Application M/56/15/HH: 31 Sea Way, Middleton-On-Sea, West Sussex, PO22 7RZ

I wish to enter my objection to the above proposed development on the following grounds:

Proposed Floor Plans
- Ground Floor
- First Floor
- Roof Plan

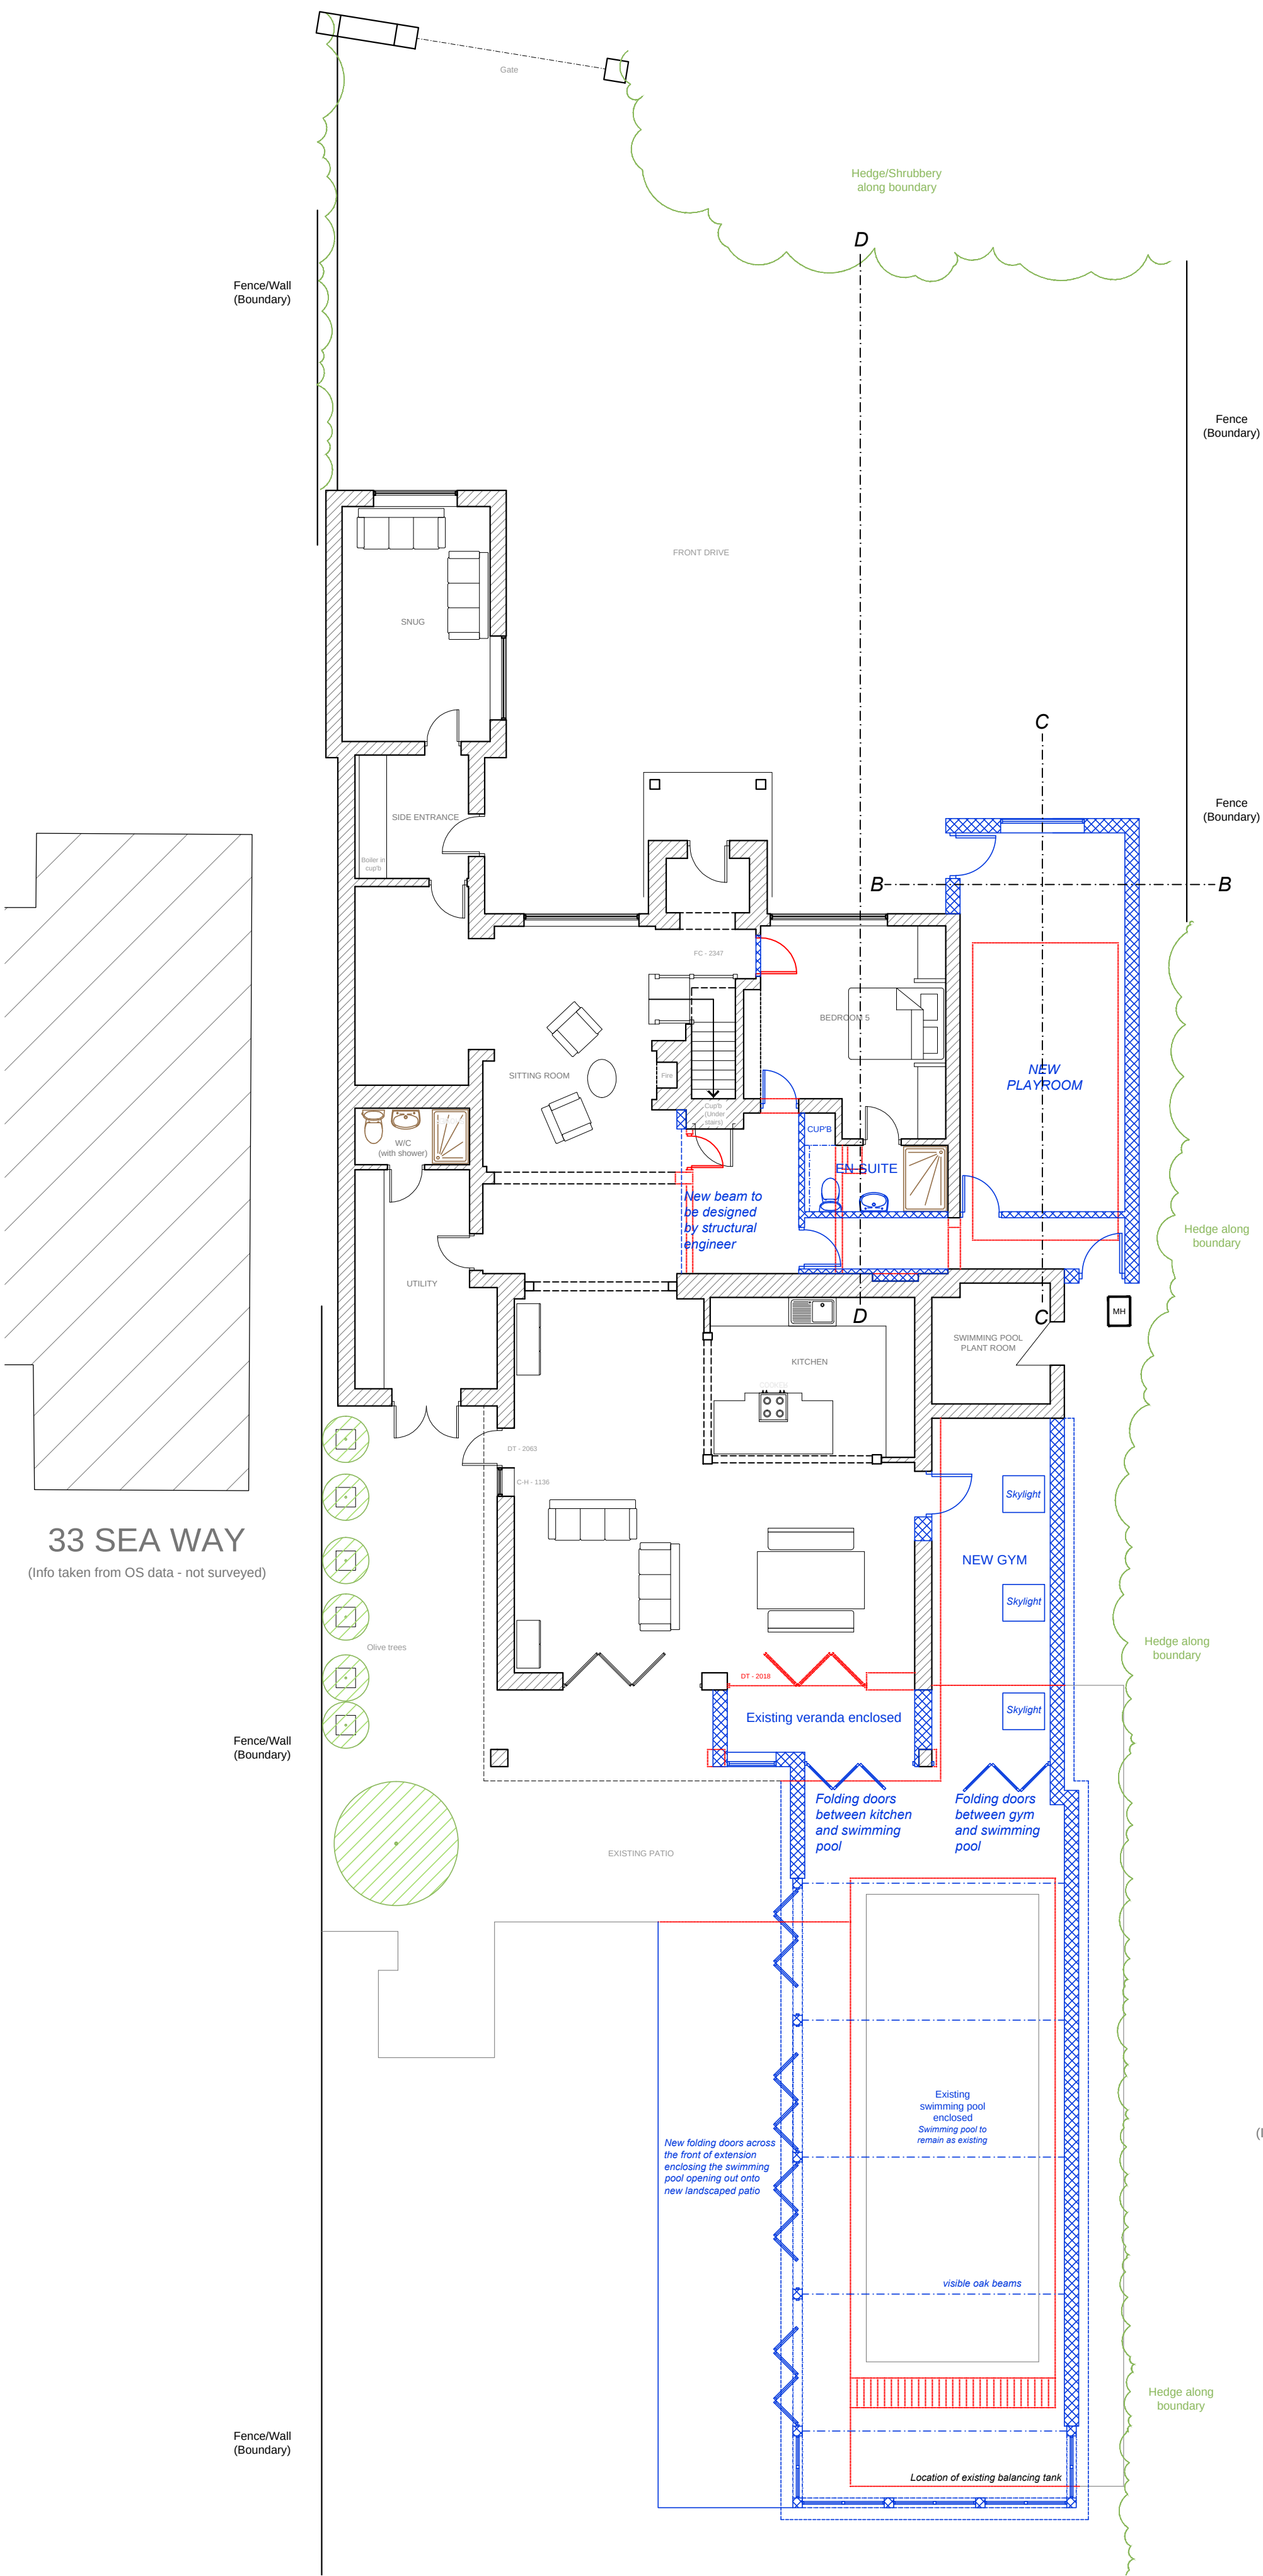
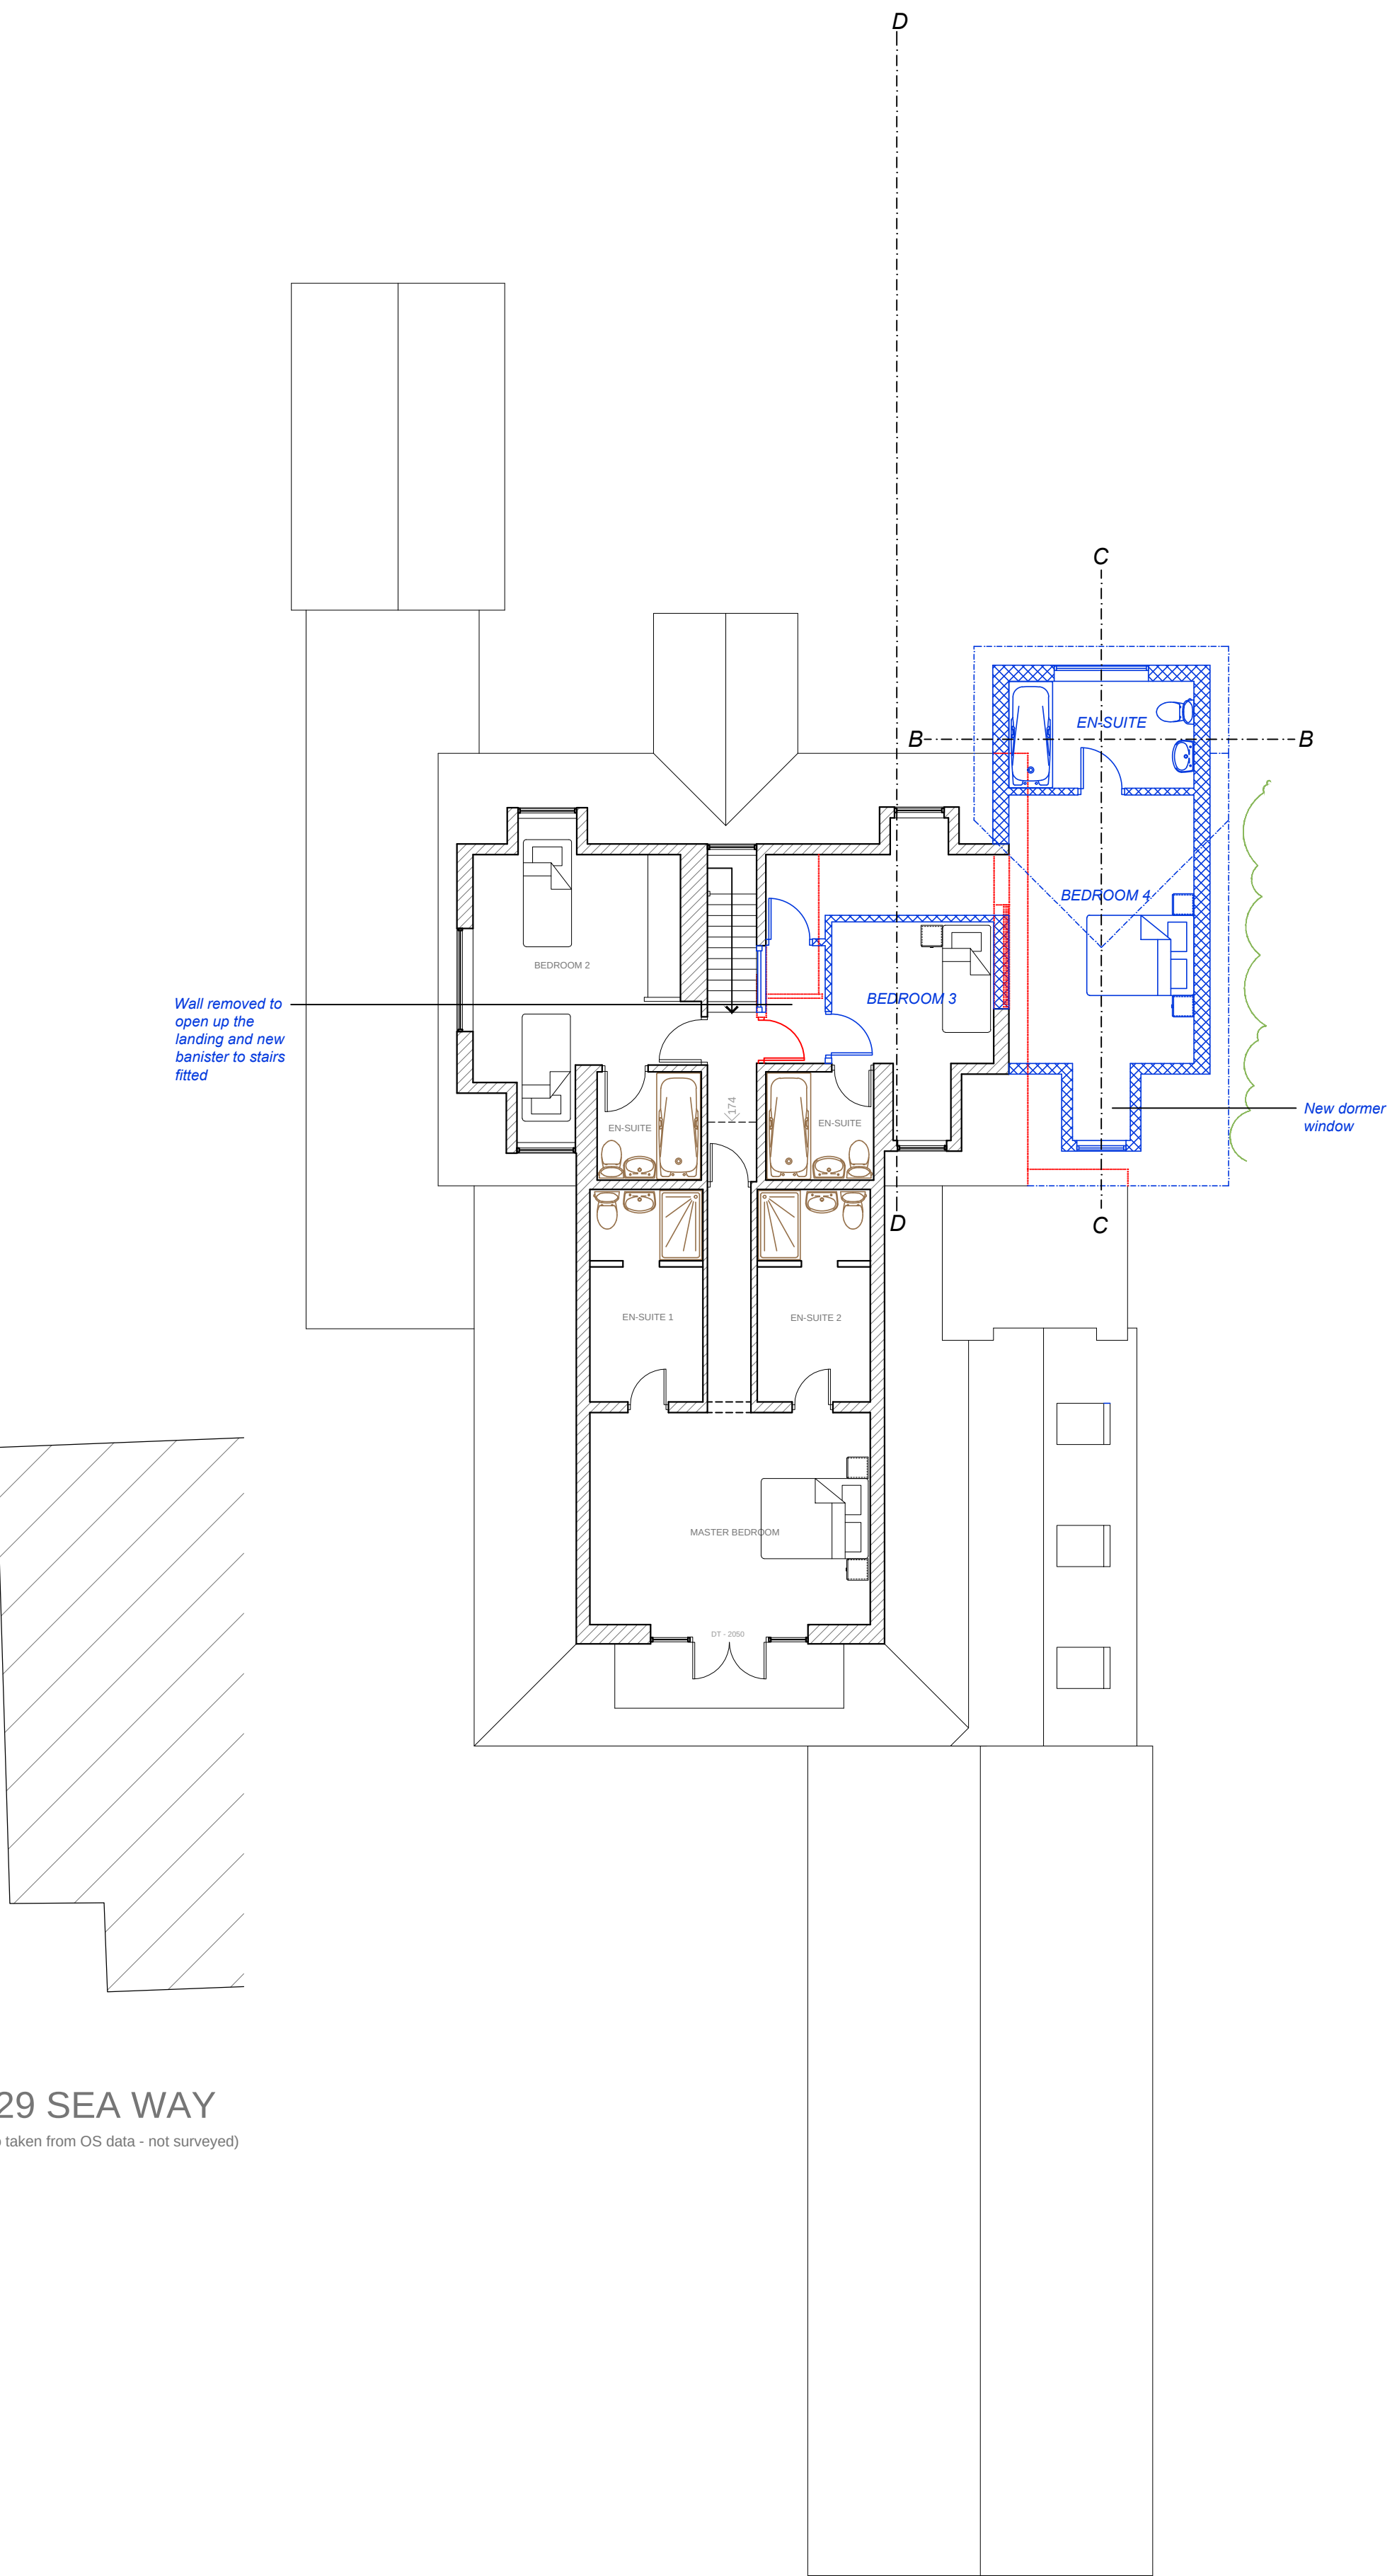
3. No part of the increased development takes into account this area of special character and the open space enjoyed by each property, I therefore concerned at the impingement of loss of light and amenity to the neighbouring property of No 29 again as a precedent for future applications and the likely changes to both the view from the seafront and road.

4. The bulk of the 'blind' wall and high pitched roof of the proposed garage building so close to the boundary line at both the east and north. The long bulk of the building will seem quite dominating – even if the current hedging or new planting or indeed a wall were in place. Again the precedent of building so close to the boundary of a property close fronting

6. The possible damage to the recently re-instated and costly land drain that runs across Sea Way Road and takes a route (rain water that drains down from West Close/East Close) directly through 'The Little House' property to egress under The Greensward and shingle and out to sea. I appreciate that this may not be seen as a planning matter but I would want to have this item noted for further consideration and a specific note attached with regard to any future planning as the weight or disturbance of the proposed building work – in particular in this case the load bearing weight of the proposed garage and high pitched roof in the front of the property as well as the support structure for the proposed pool enclosure could materially affect the ability of the drain to work effectively.
